SSD-13166280 – Blind Creek Solar Farm – LOT: 17 DP: 535180, LOT: 1 DP: 456698 – 114 Currandooley Road, LAKE GEORGE

Transport for NSW (TfNSW) is responding to the SSD-13166280 referred on 18 November 2022.

TfNSW has reviewed the information and is unable to properly assess possible impacts of the proposed development on the State Road network and its users and does not support the proposed development in its current form. Details of additional required information are set out in Attachment 1.

DRAWN: CT  
DATE: 12.04.2022  
SCALE: 1:750 @ A3  
DWG NO: 167-S02A

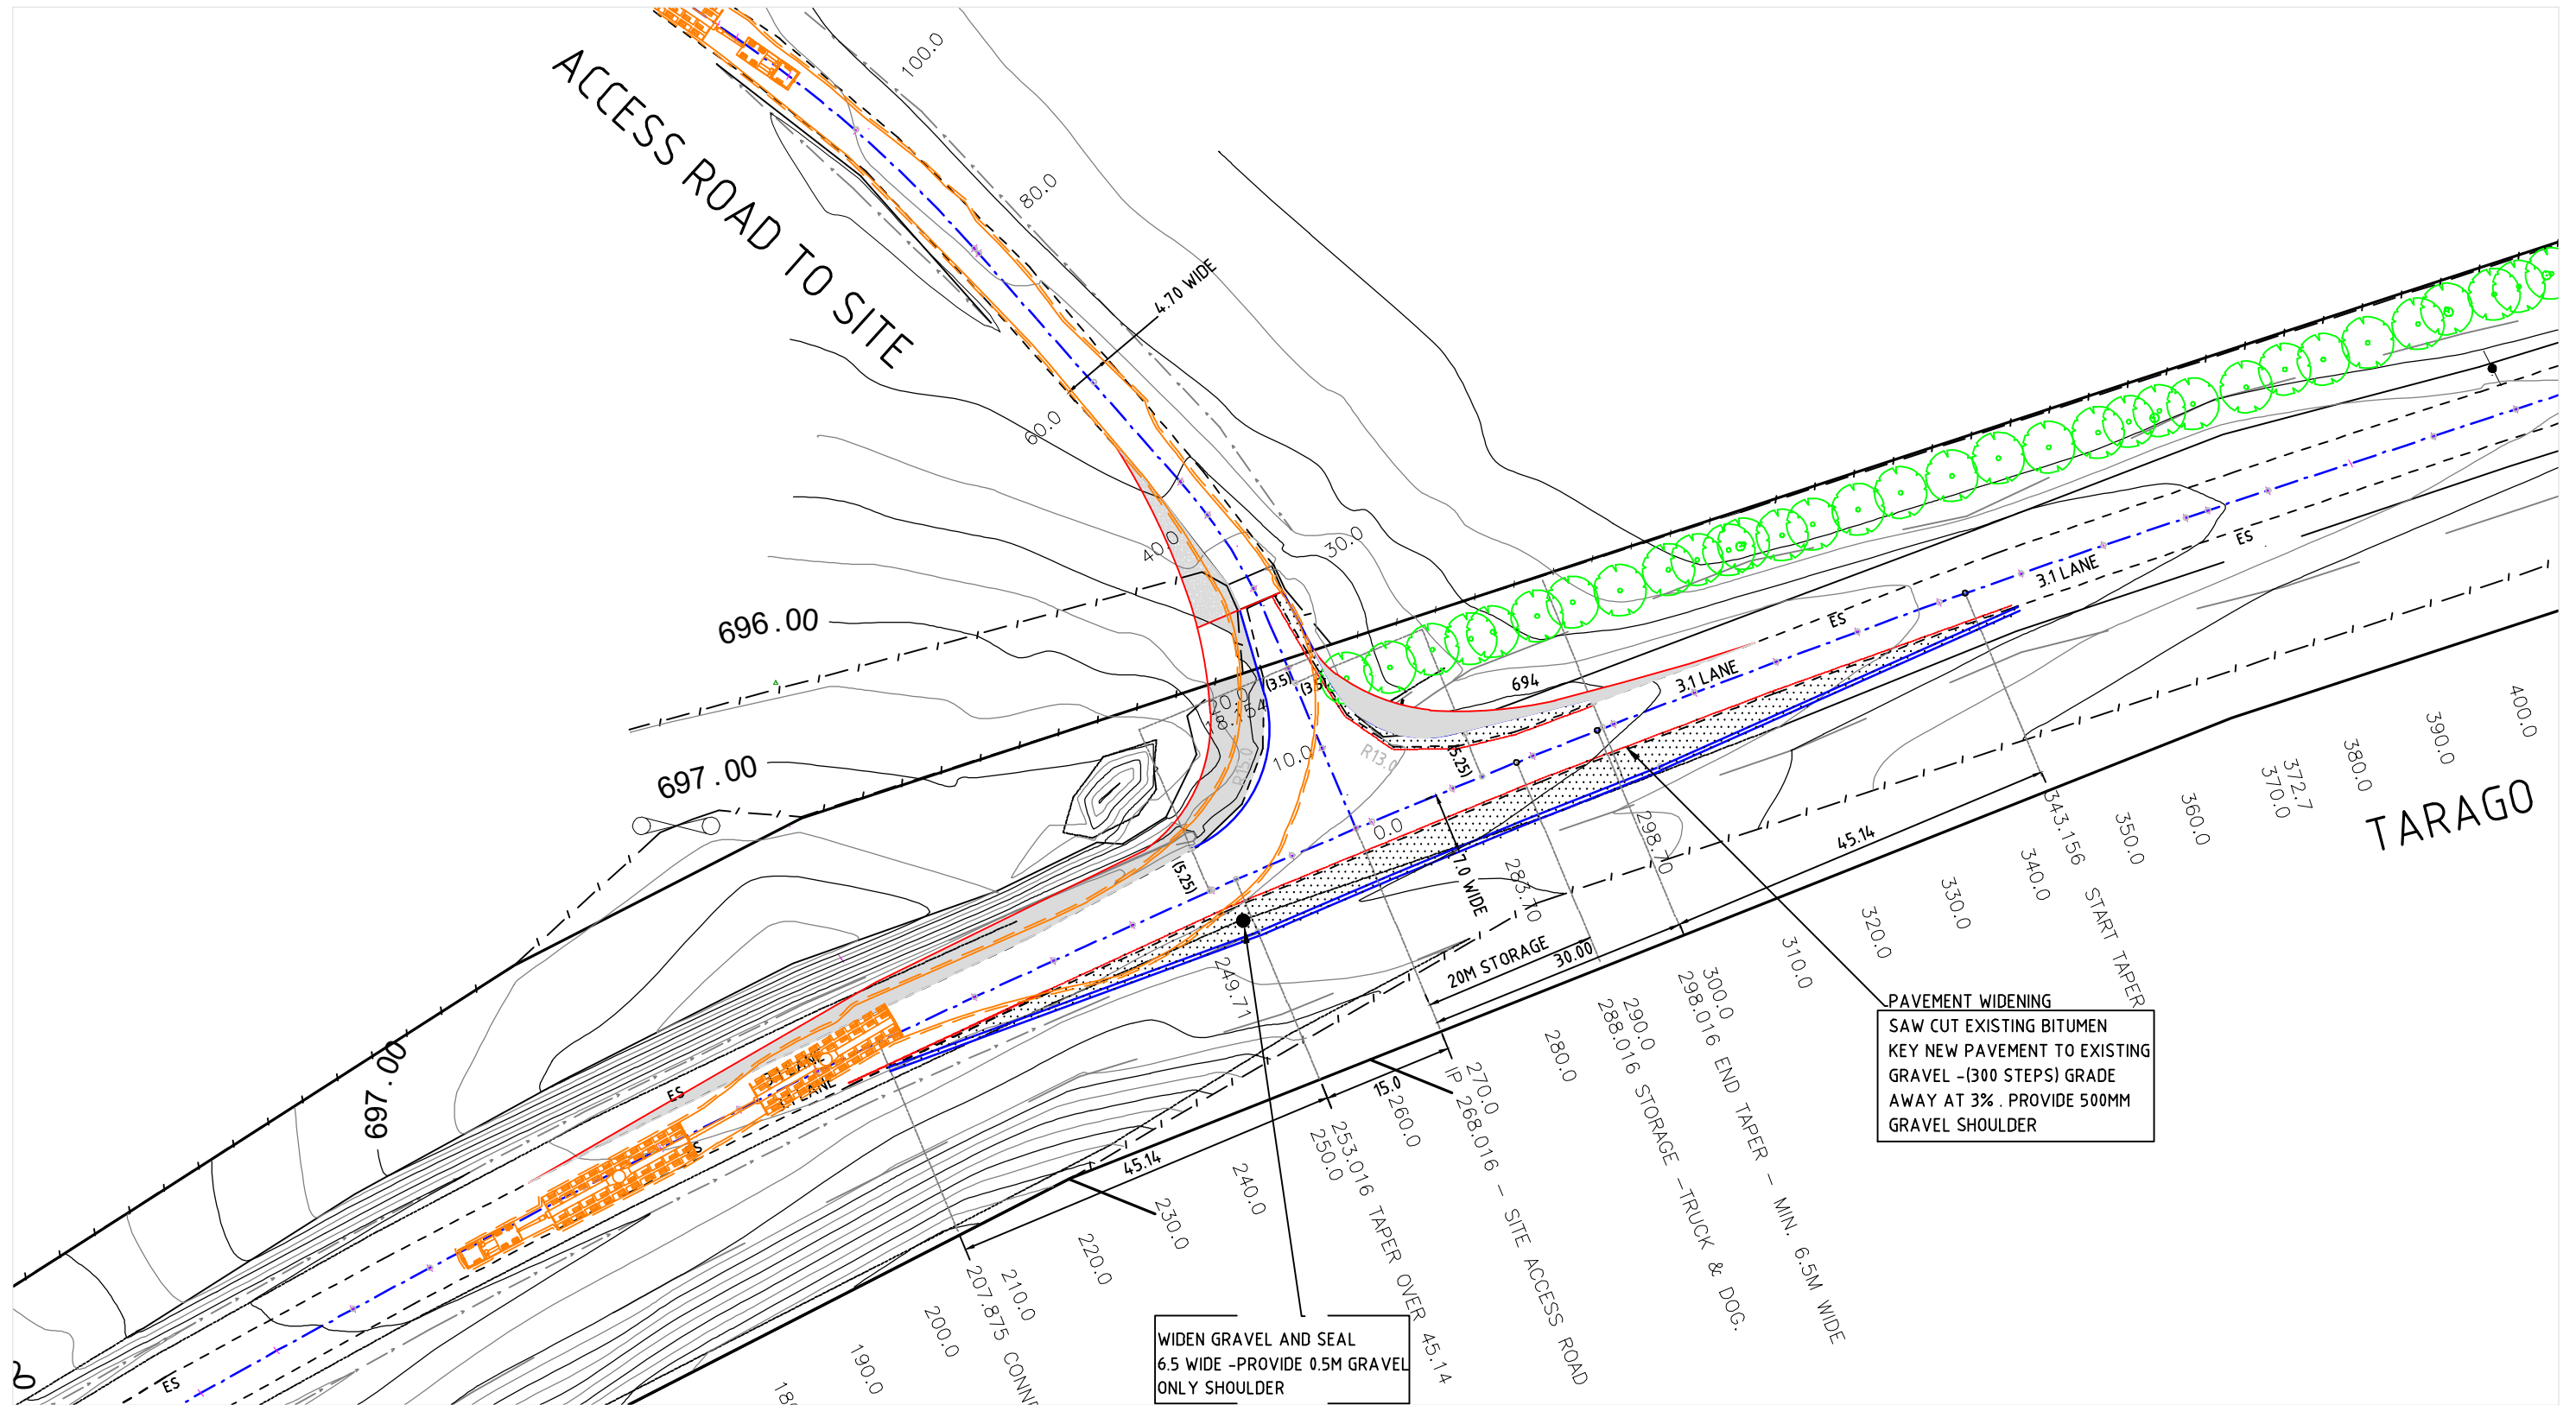
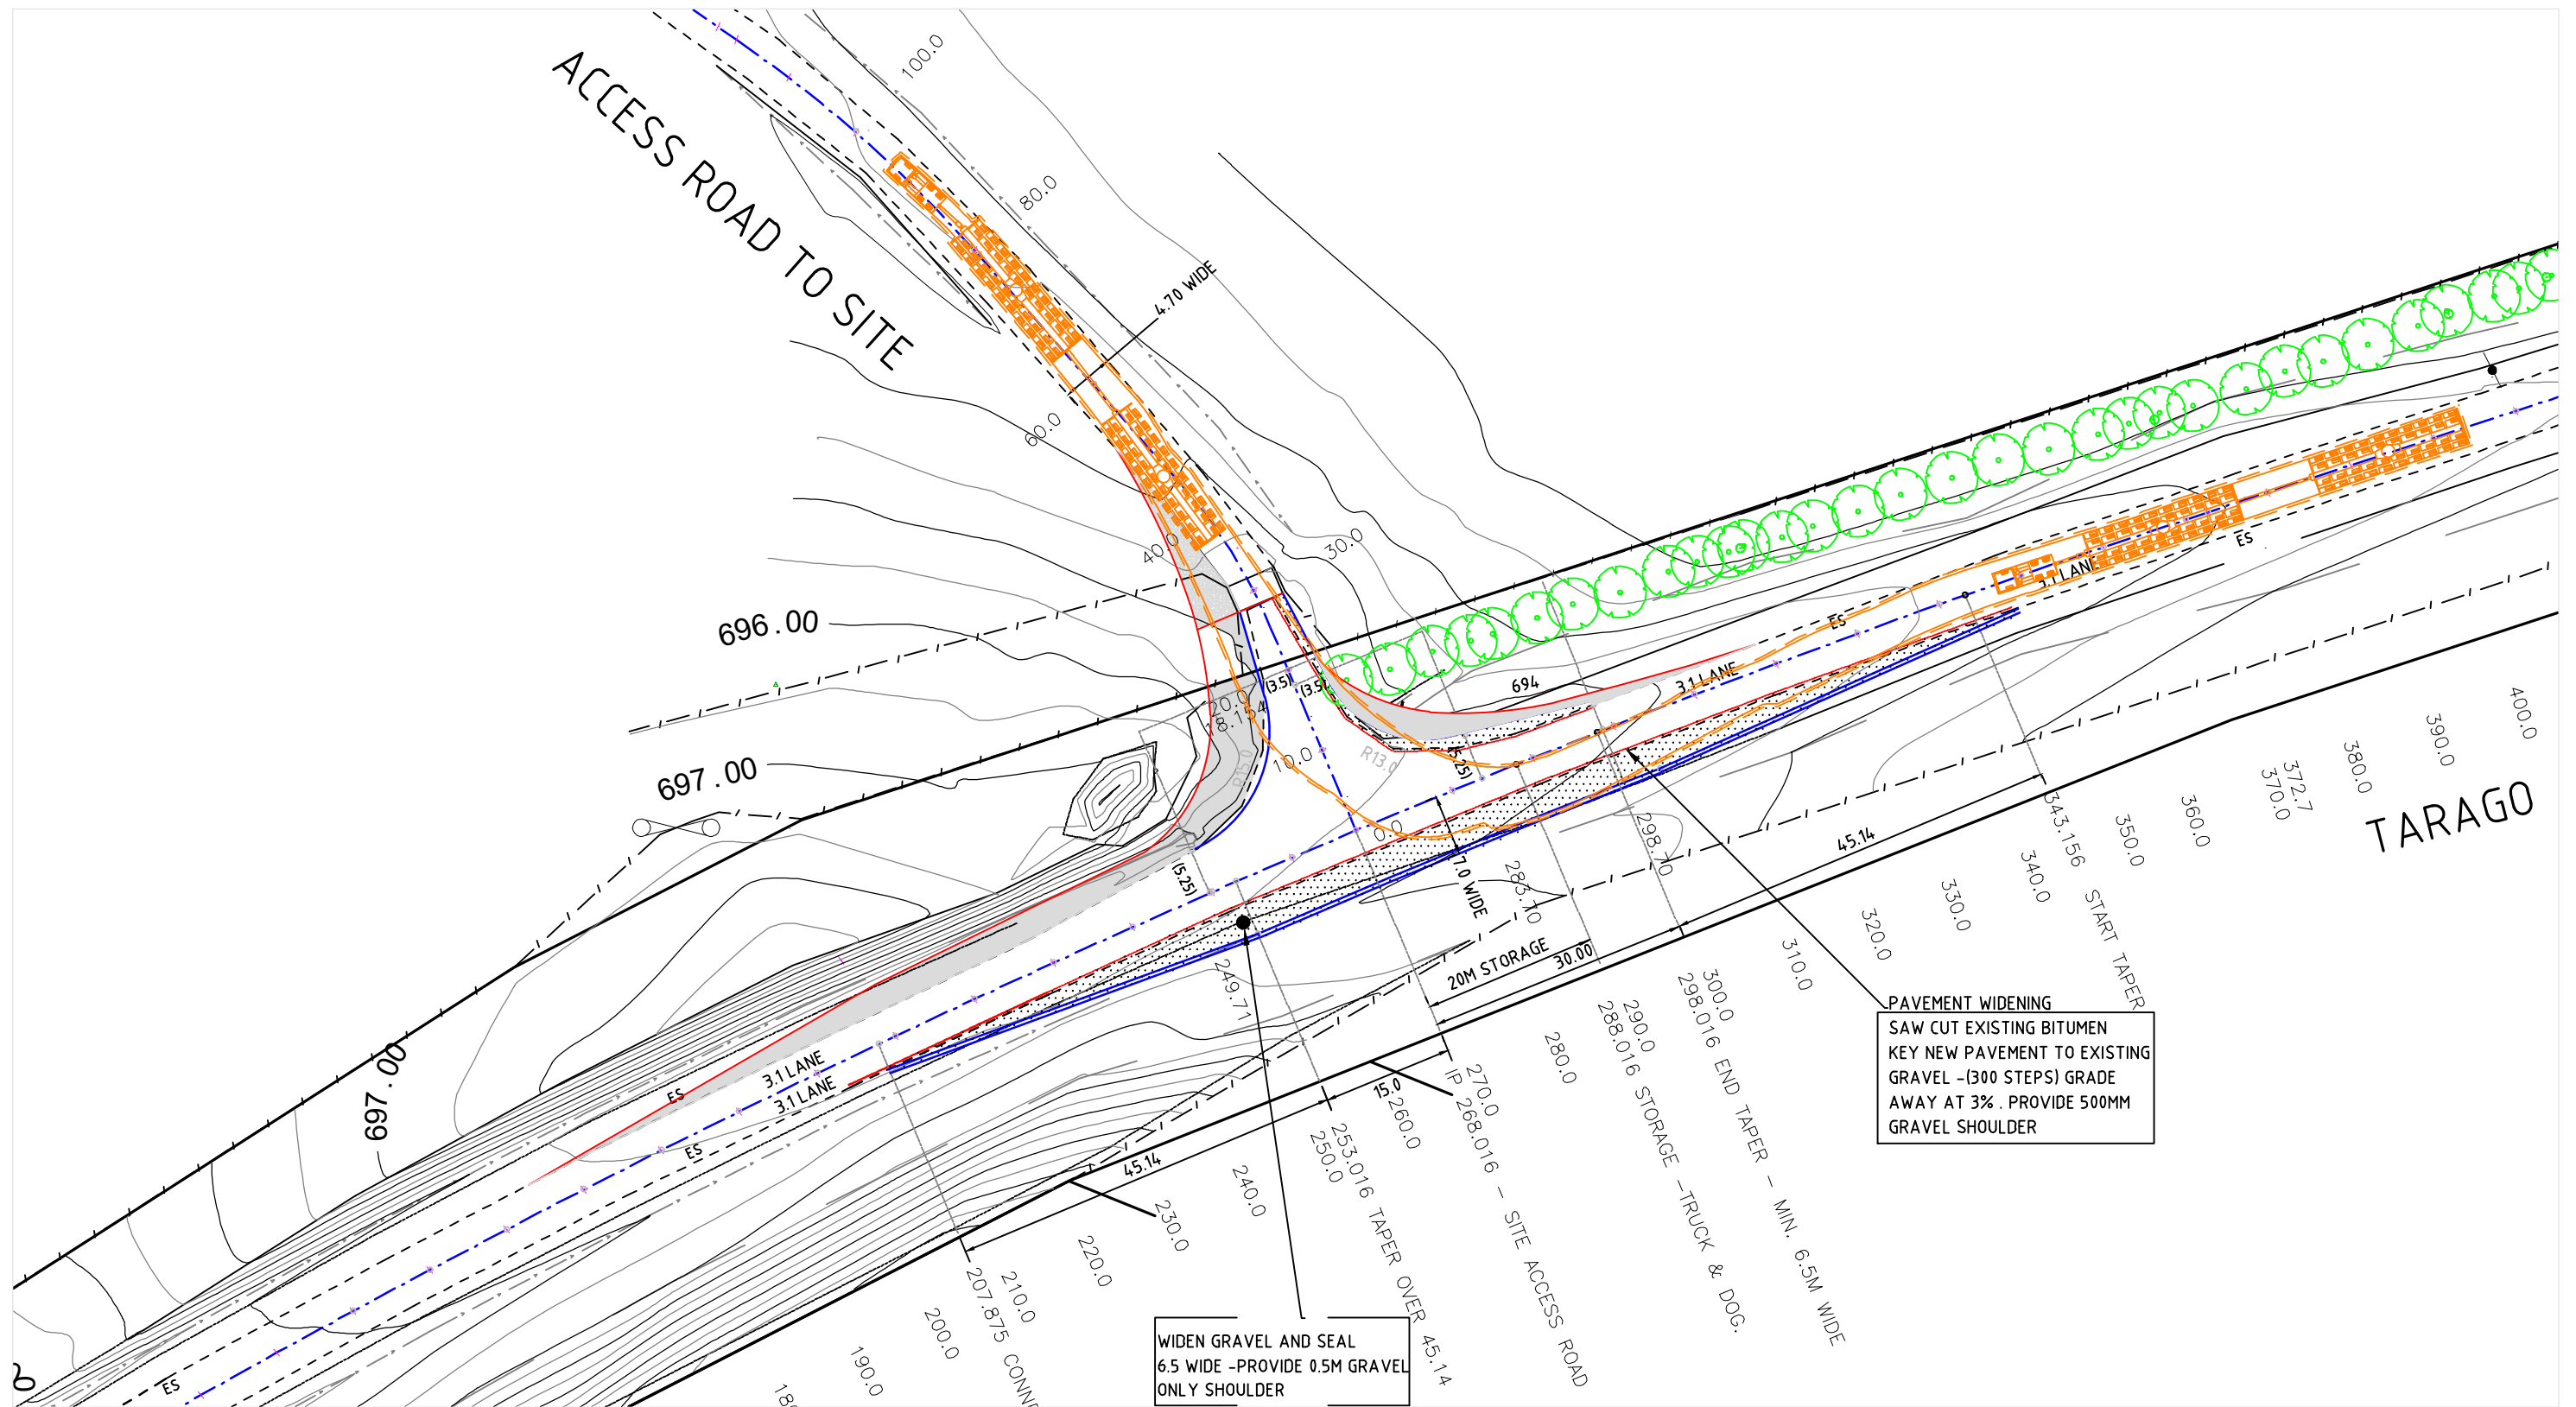
- Oversized and B-Double vehicles: Details are required on any B-Double and OSOM movements associated with the proposal as well as details on the route these vehicles will take (including a route map and swept paths of the relevant intersections) and any changes to the road network required to cater for B-Double and OSOM movements (e.g., removal of infrastructure, widening works, vegetation removal, etc).
